From: Zac Denton
Sent: 12 August 2020 13:46
To: Planning.Responses
Subject: FW: FG/68/20/HH

From: Martin Down [REDACTED]
Sent: 12 August 2020 13:42
To: Zac Denton [REDACTED]
Subject: RE: FG/68/20/HH

I am writing to object, in the strongest possible terms, to the transformation of the flat roof to the rear of number 9 East Onslow Close into a usable outdoor space in any form.

RETROSPECT PLANNING PERMISSION FOR PROPOSED BALCONY (DOC 002)

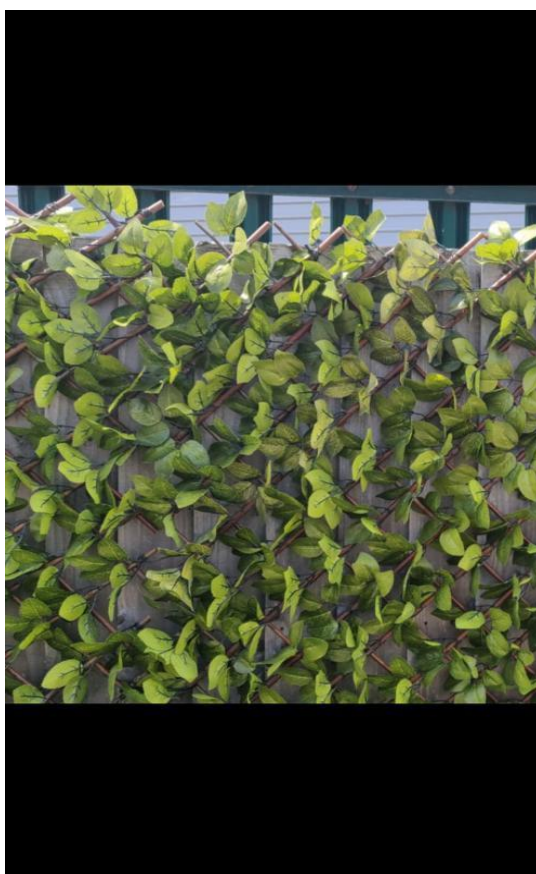
When you carry out your site visit, I invite you to come and sit in our summerhouse and on the benches by our pond, where we go to relax, to see how this alteration next door has robbed us of our privacy. The current proposal is for "artificial laurel trellising" to the north elevation. Such screening is wholly inadequate as it is full of holes (no pun intended). We are, in fact, overlooked by the north, south and east elevations, to the front and rear of our property. It is, in effect, a viewing platform for a sizable portion of our outdoor space.

PROPOSED BALCONY BALUSTRADE ELEVATIONS
AT 9 EAST ONSLOW CLOSE
FERRING
WEST SUSSEX BN12 5RR

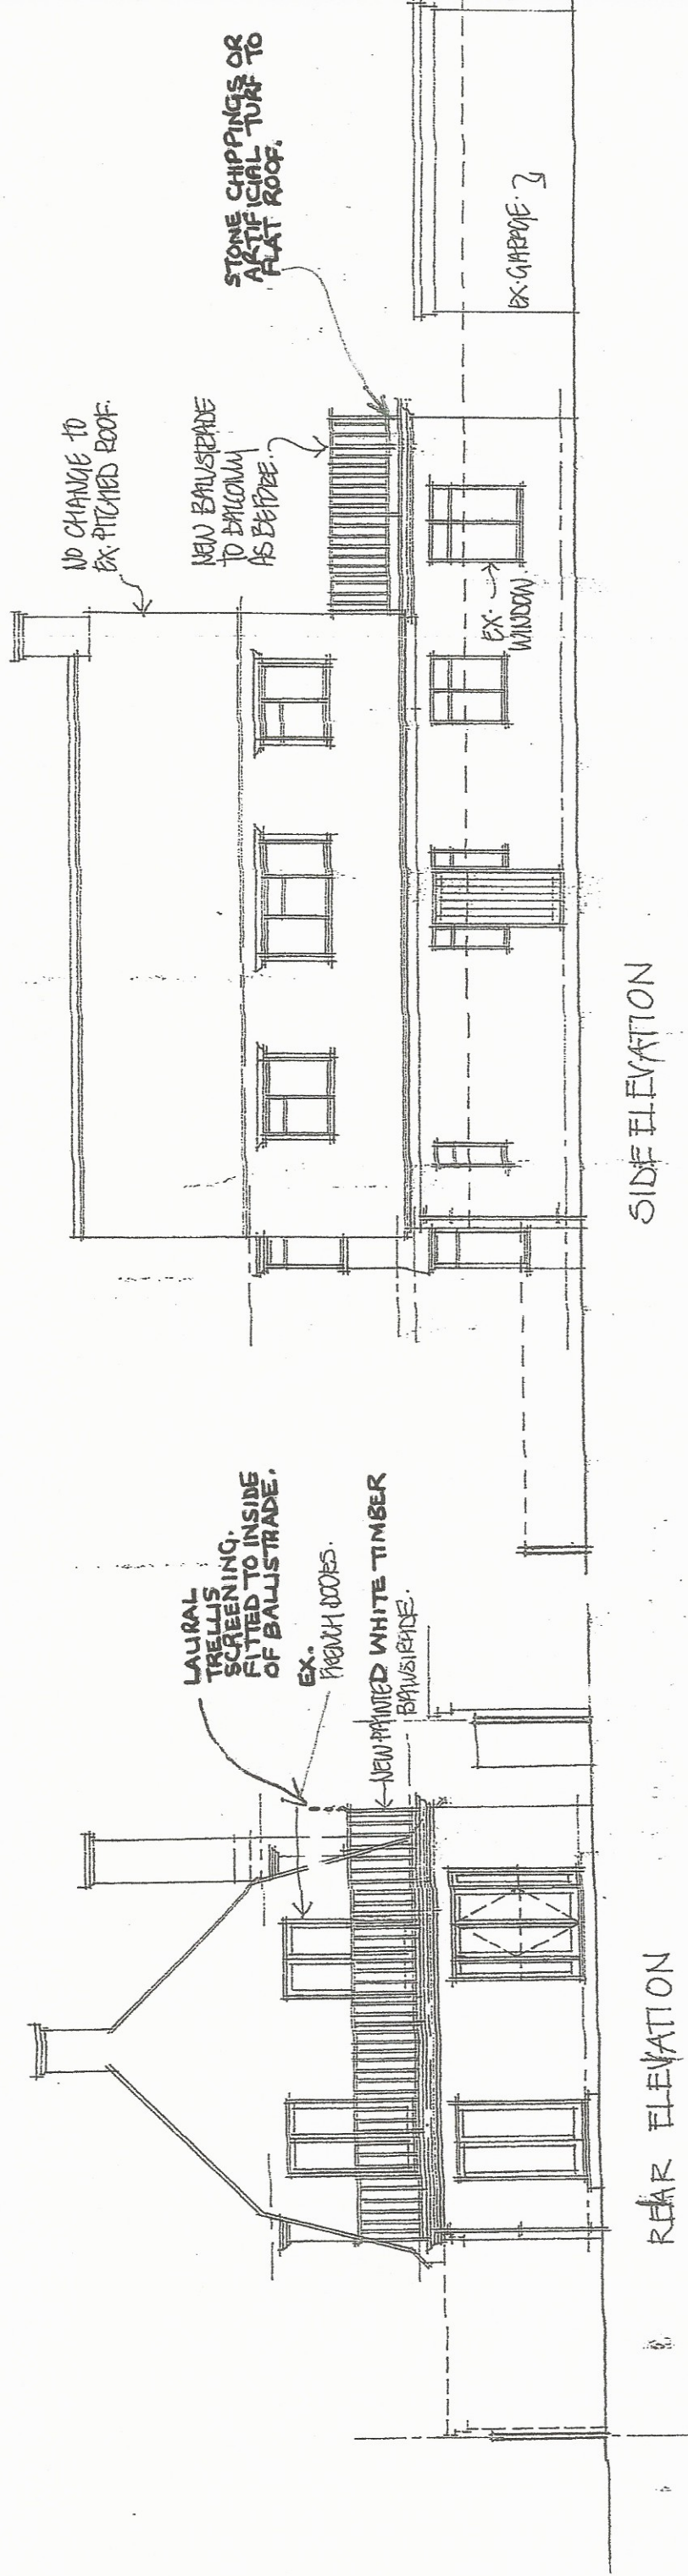
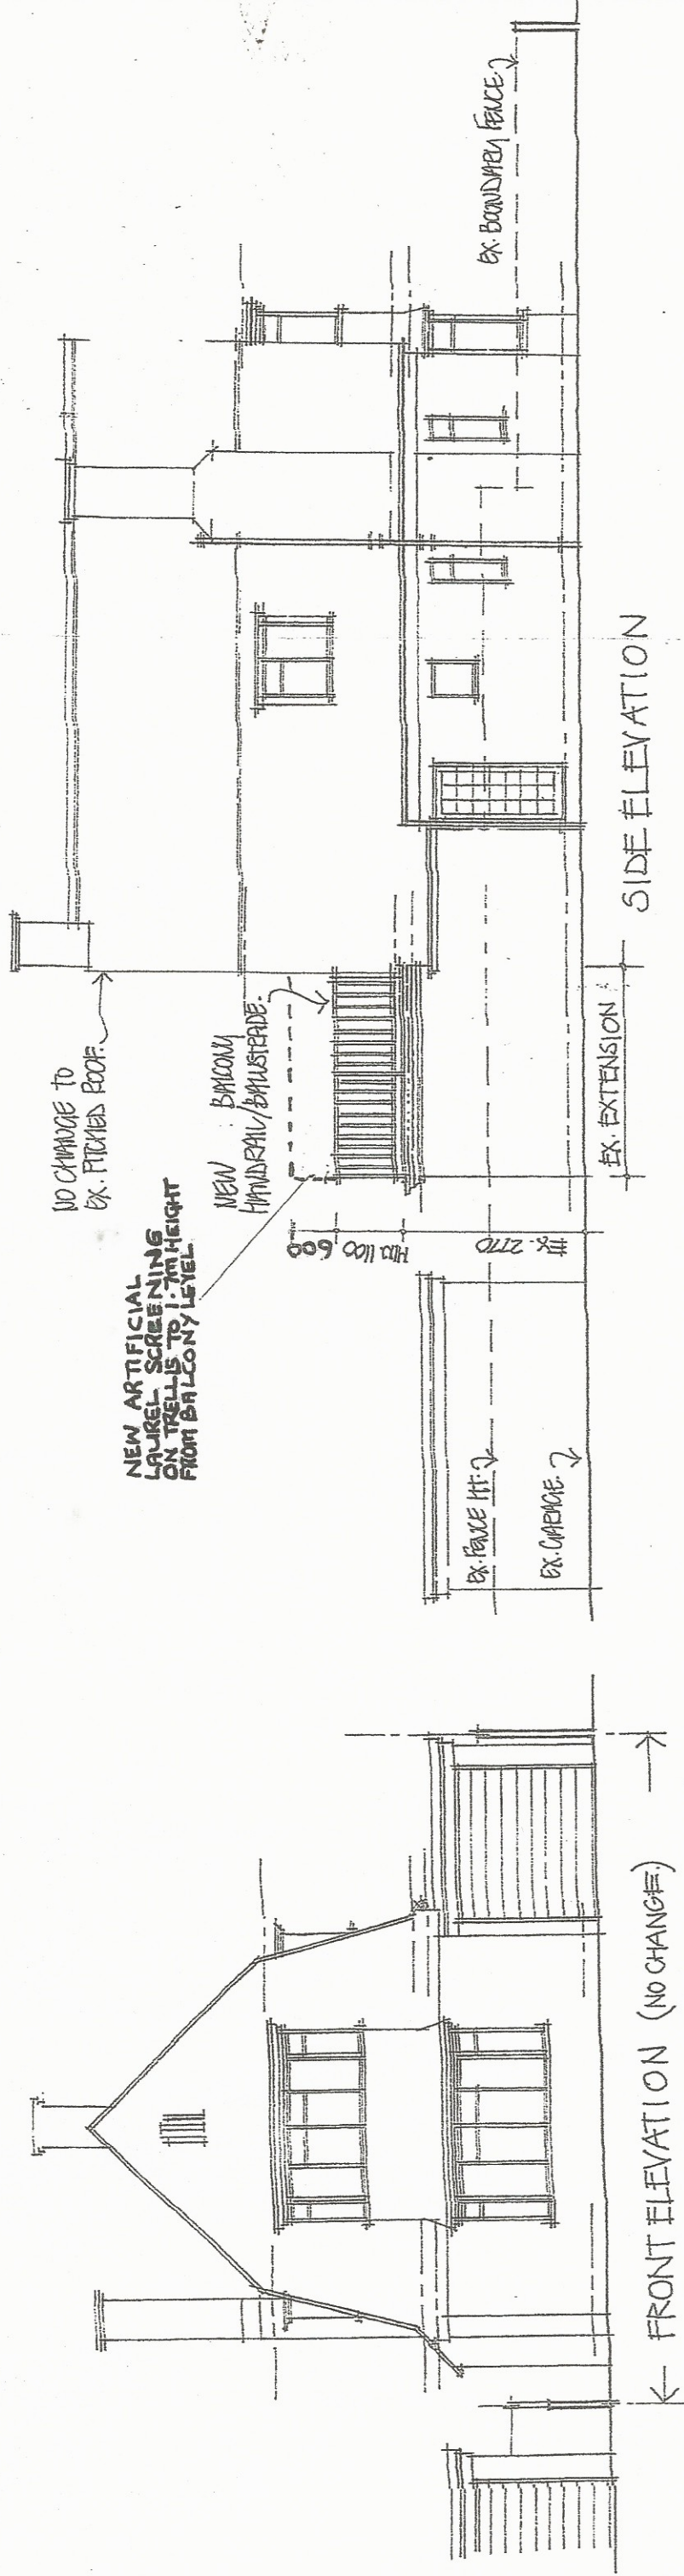
Ms Jackson mentions her objection to the required screening due to its similarity to a shower cubicle, I feel that the current balustrade resembles a child's playpen and that her proposal would be like a plastic jungle. The only aesthetically pleasing solution is to go back to an unadorned, unencumbered and unusable flat roof.

To summarise, the current balcony robs my family of our privacy and totally changes the way we feel in our front and rear gardens, negatively impacting our quality of life. The proposed nod towards screening does nothing to diminish this in any way. A full, wrap-around screen would create, in effect, a roofless, unsound-proofed, second-storey extension. None of these options seems desirable to me. I would ask that retrospective planning permission be denied and that the flat roof be returned to its original state.
